From: Sue Howell
Sent: 06 July 2015 15:44
To: Planning.Responses
Cc: Simon Davis
Subject: RE: Planning Consultation on A/73/15/DOC

Comment from Greenspace

APPLICATION **A/73/15/DOC**
NO:

Site Address: The Vinery Poling

drawing number: **LP1976/S1/P/01**

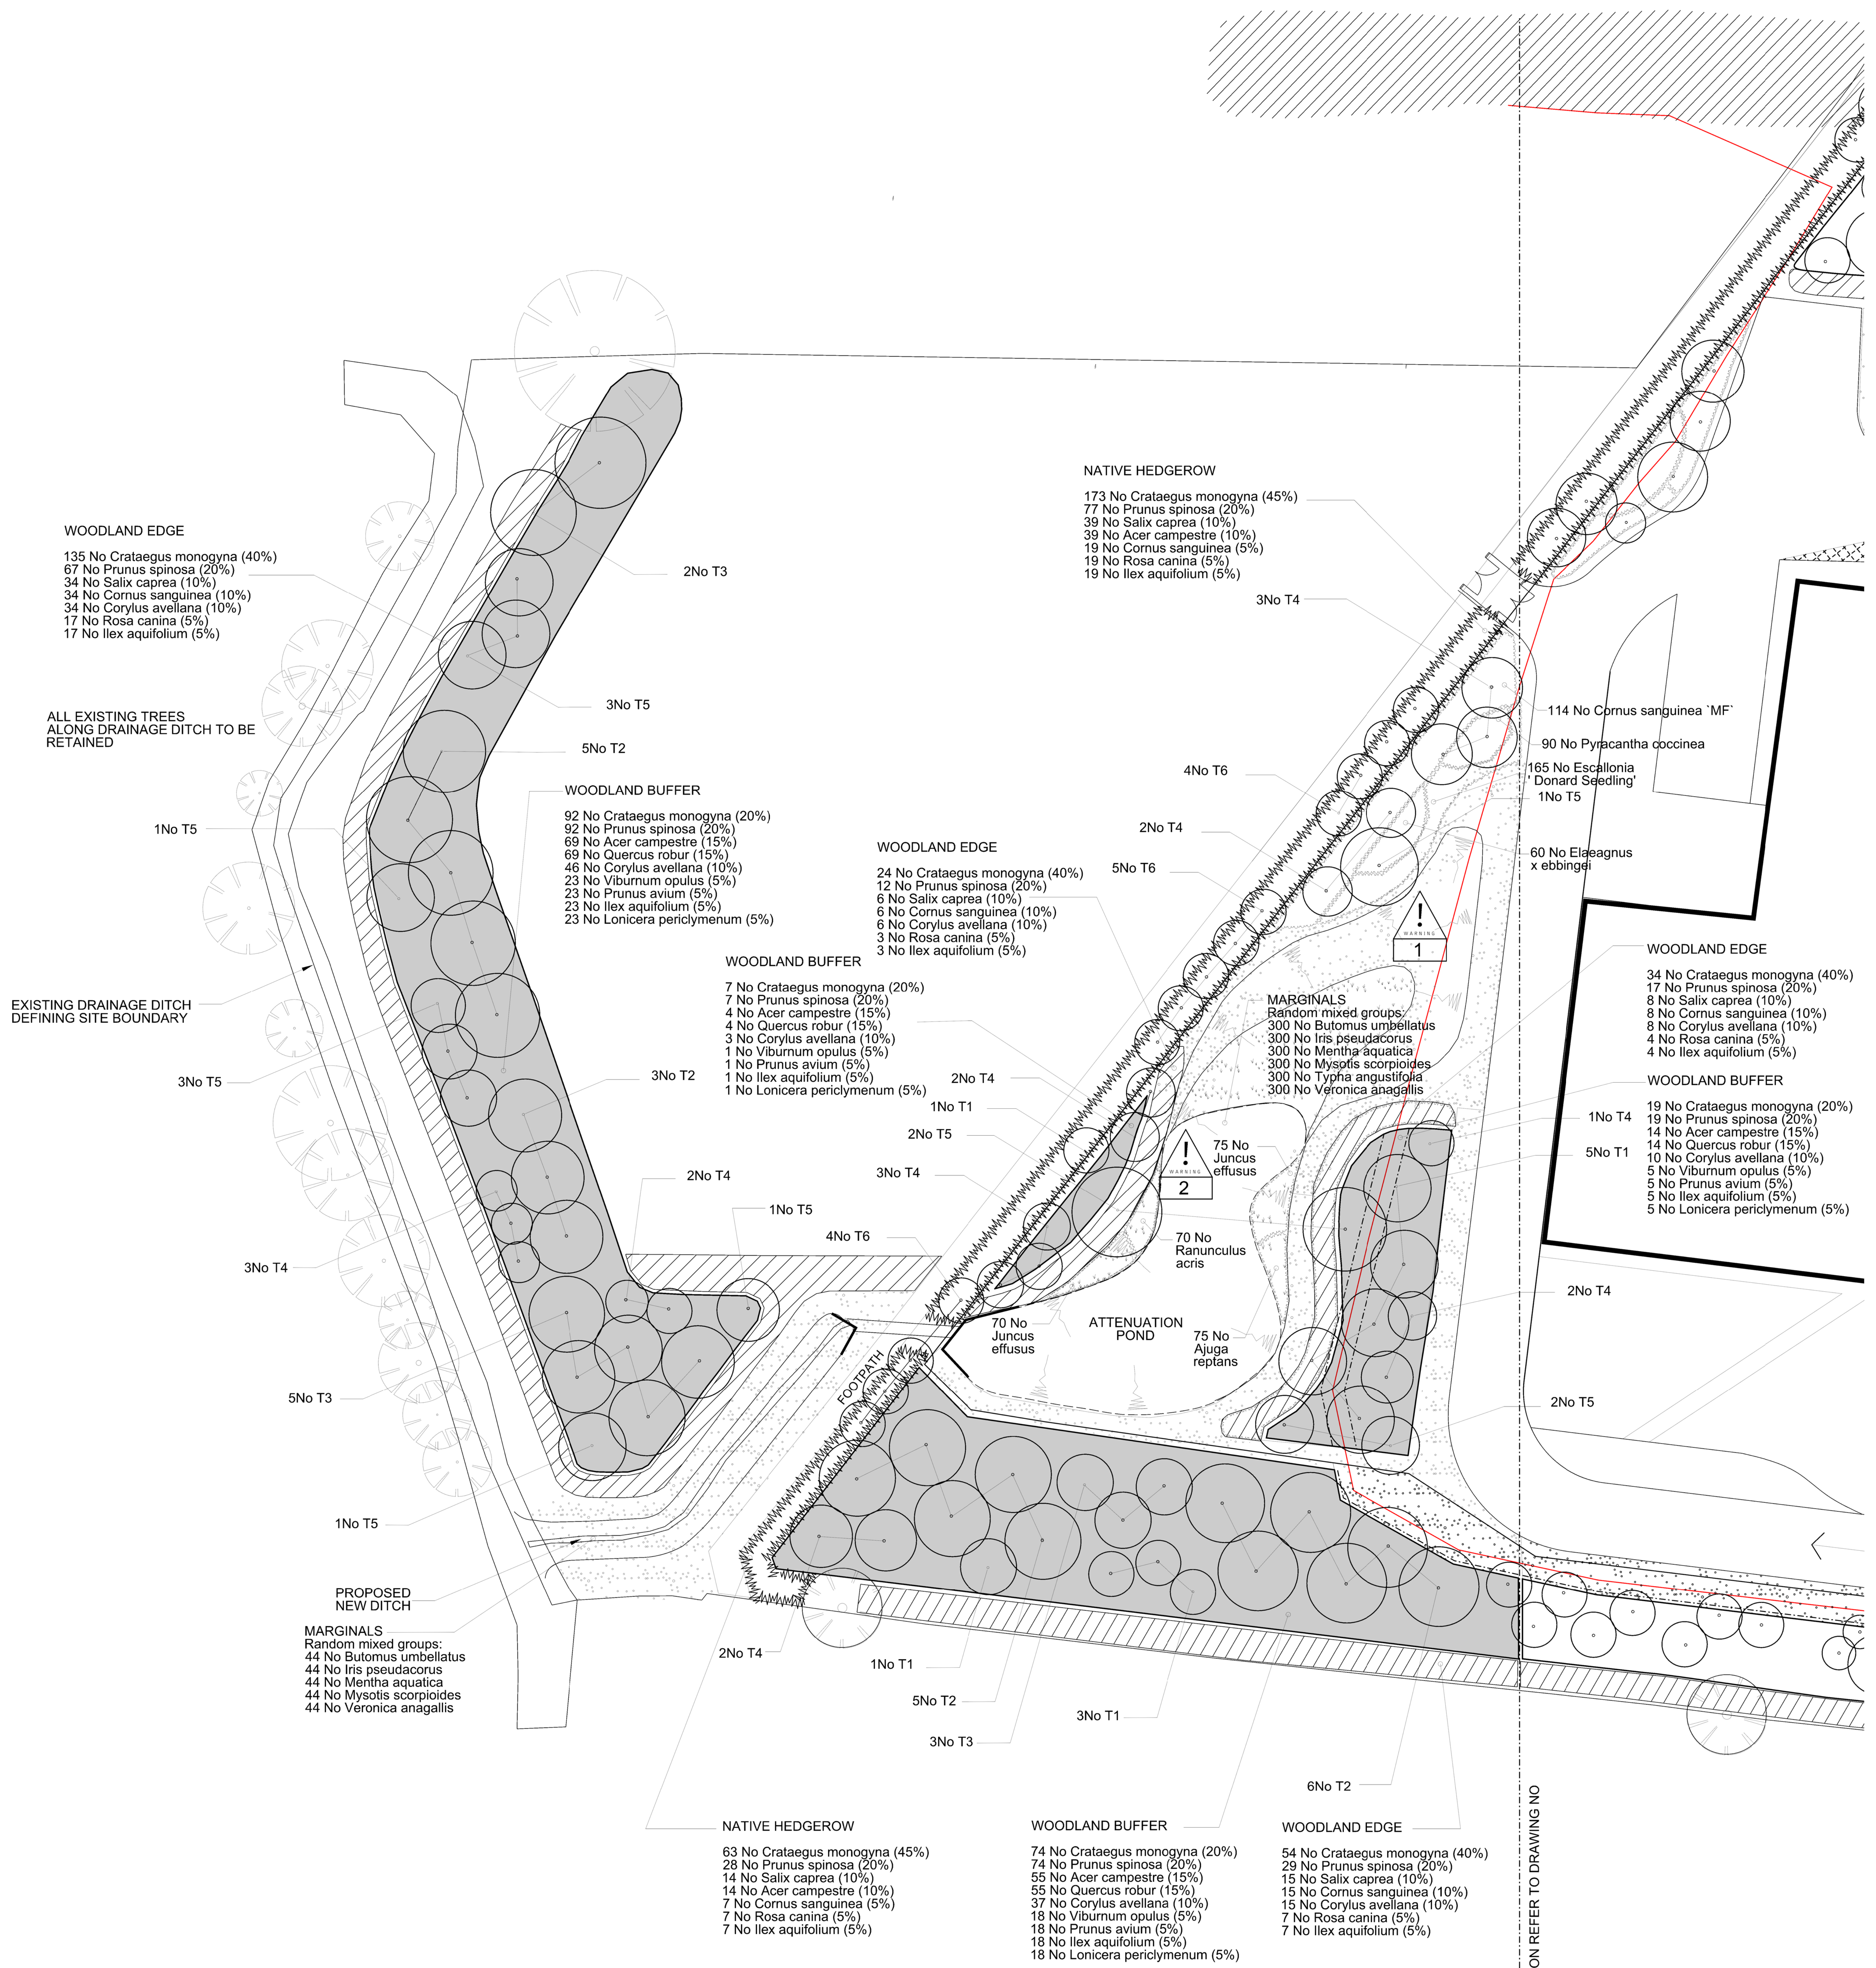
Following application A/74/13 The drawings LP1976/S1/P/01, LP1976/S2/P/02, LP1976/S3/P/03 Revision 02 propose a well thought out and comprehensive scheme which will adequately form a softening/screening effect to the proposed building structure. It is adequately detailed with trees, shrubs and native species which will add good biodiversity to the site. The revised drawings which now represent the amendments to incorporate the route of the HV cable are sufficient (subject to plant sizes previously specified) **for us to recommend the discharge of Condition 18 on this application**
